**Proposed Sea Link Project (the “proposed Project”)
Consultation on proposed changes to the Sea Link development consent order**

We previously wrote to you to consult you on National Grid Electricity Transmission’s (NGET) proposals for Sea Link, a new primarily offshore 2 gigawatt high voltage network reinforcement between Suffolk and Kent. Our application for development consent was accepted in April 2025. We are currently preparing for the start of the formal Examination of our proposals in November 2025.

Document 9.3.3 Suffolk Section Phase 2B Archaeological Evaluation Report Extract illustrating the location of the henge in relation to the proposed scheme

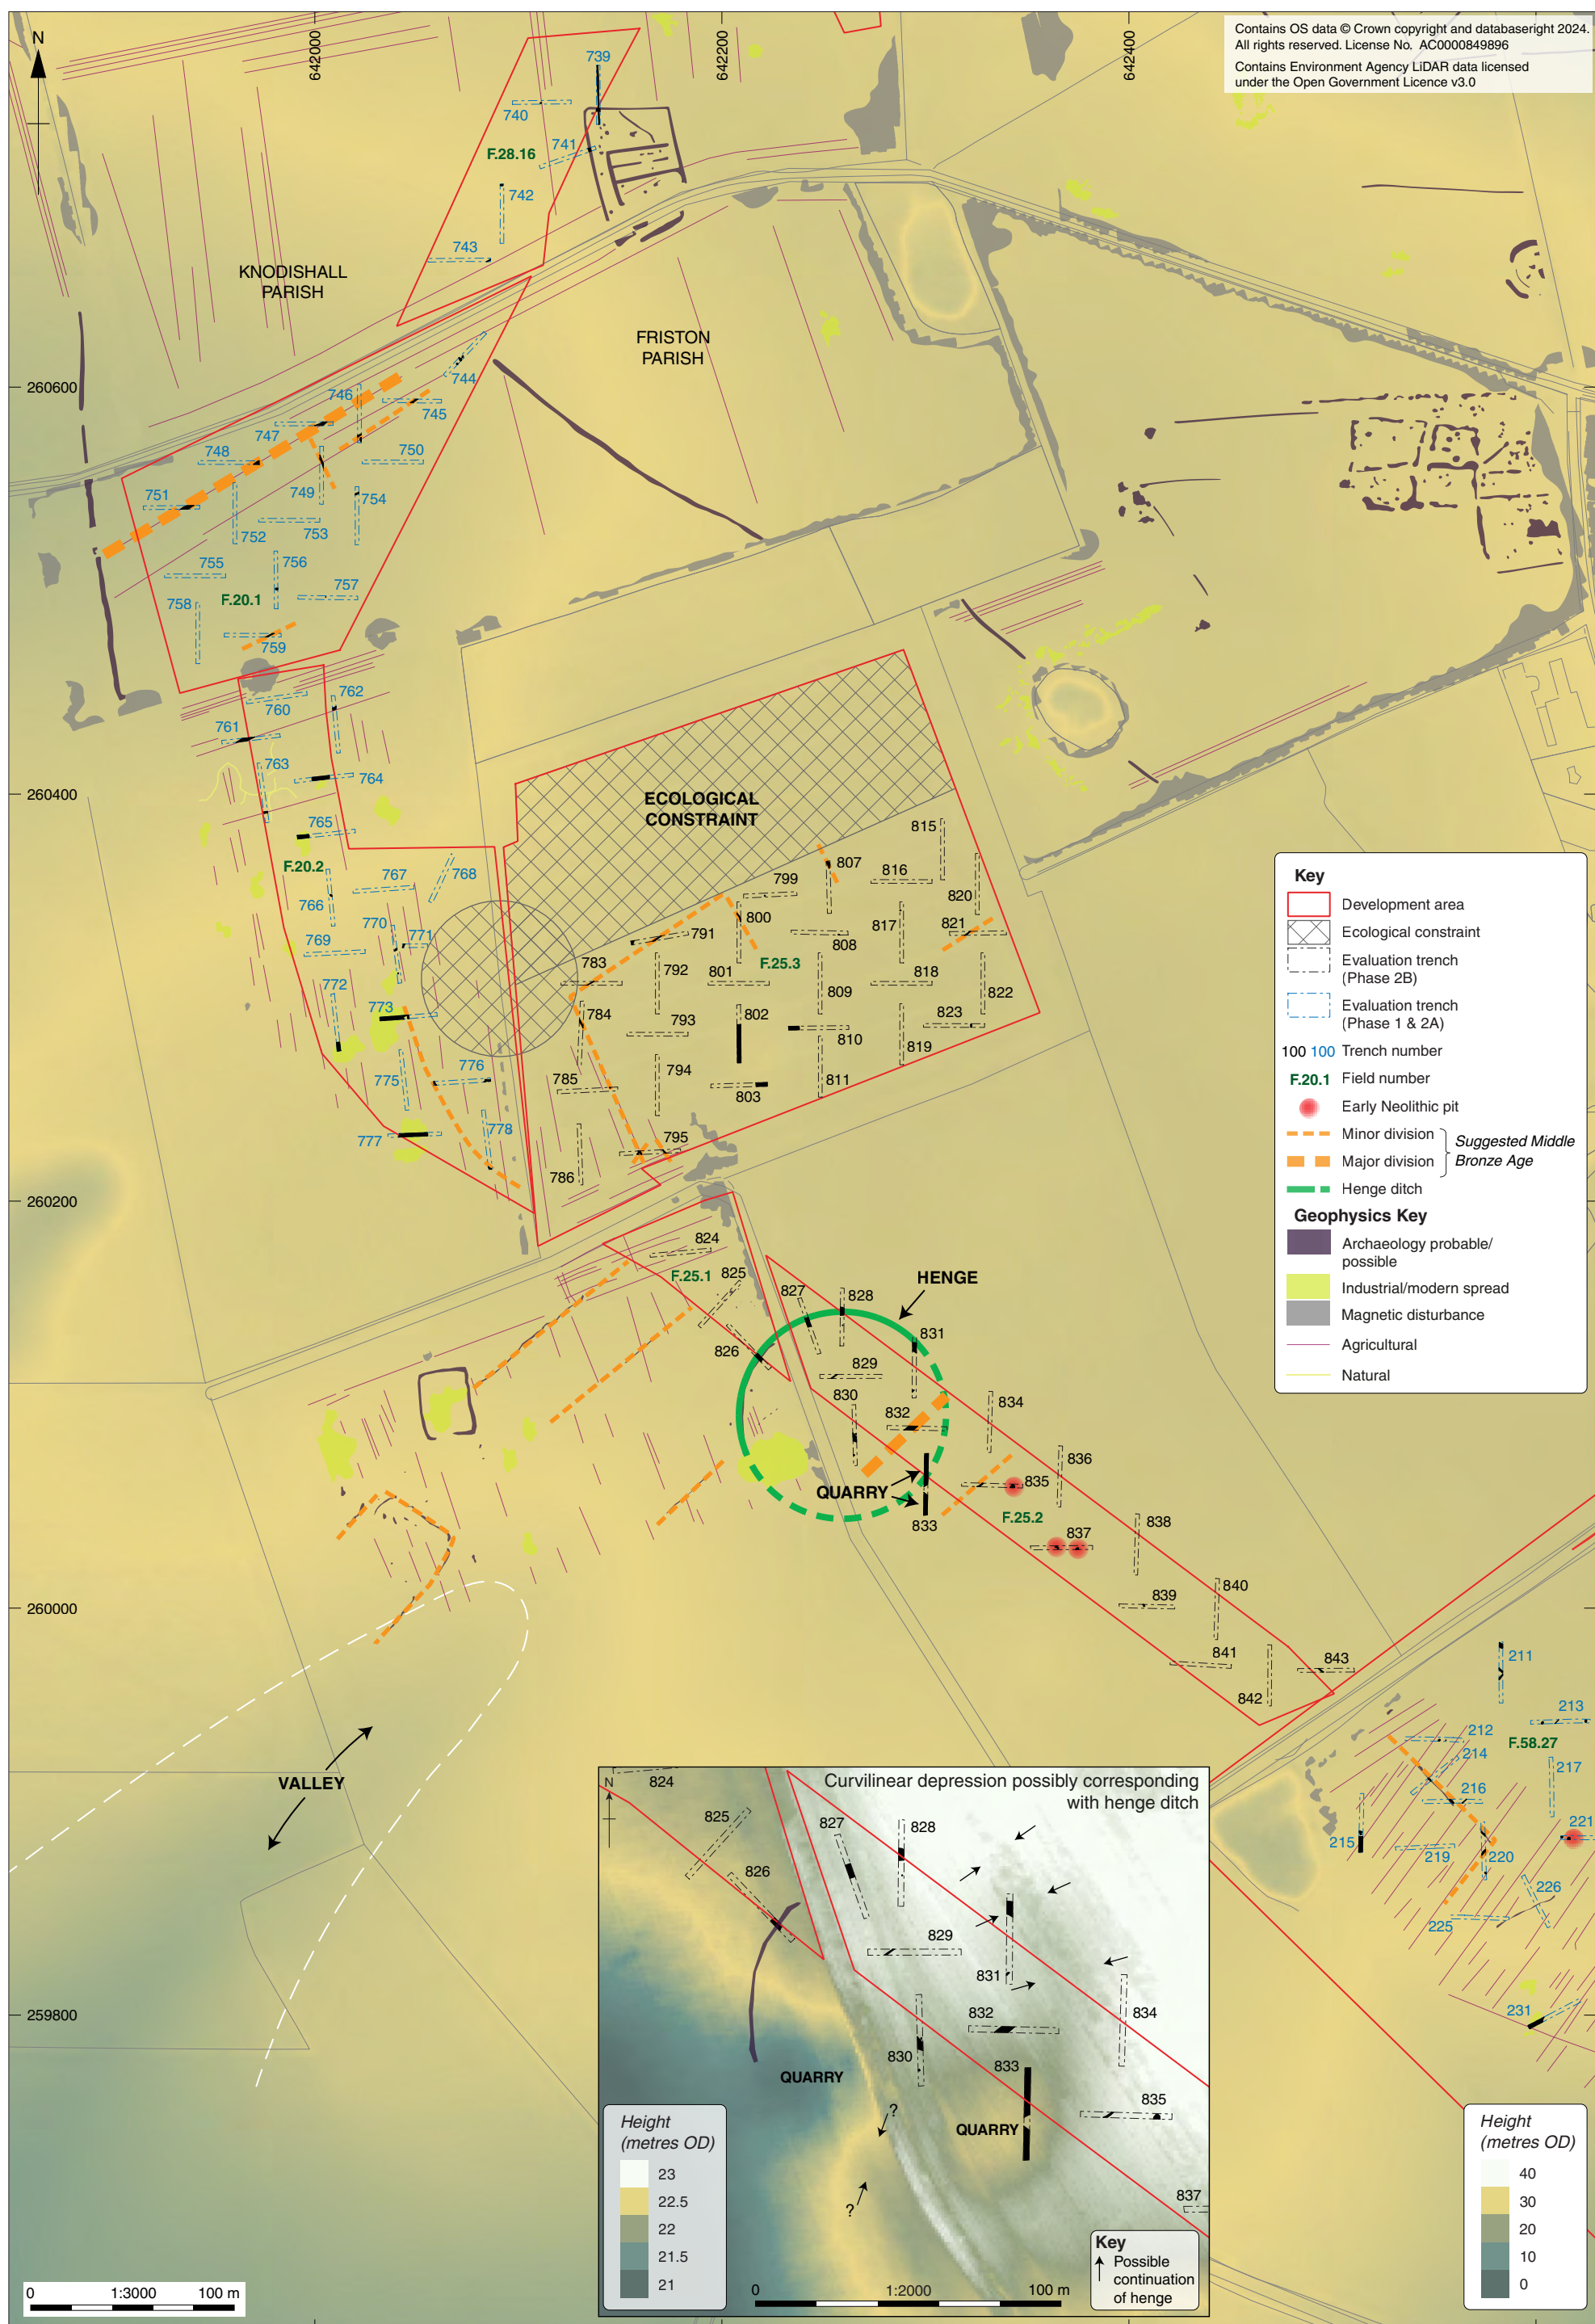
As part of archaeological investigations, we recently identified the site of a previously unknown hengiform monument along our proposed underground cable route to the east of Friston. The finds within the henge date back to the Neolithic period, meaning that they are approximately 4,000 to 5,000 years old. Finds like these are relatively rare in Suffolk, and it is considered to be of high value.

We are therefore proposing to remove the Neolithic henge feature from the Order limits and include additional land either side of it to route the underground cable. The underground cable and temporary haul route would then be located more than 30m from the monument and would not result in harm to the henge. Both Historic England and the Suffolk County Archaeologist agree that our proposed approach is the best solution.

We will undertake further survey works in this area to identify a precise route for the underground cables in the additional land we are proposing to include in our Order limits. We are not expecting this change to alter the conclusions of the Environmental Statement included in our development consent order application. Incorporating the proposed change would avoid a potential significant environmental effect.
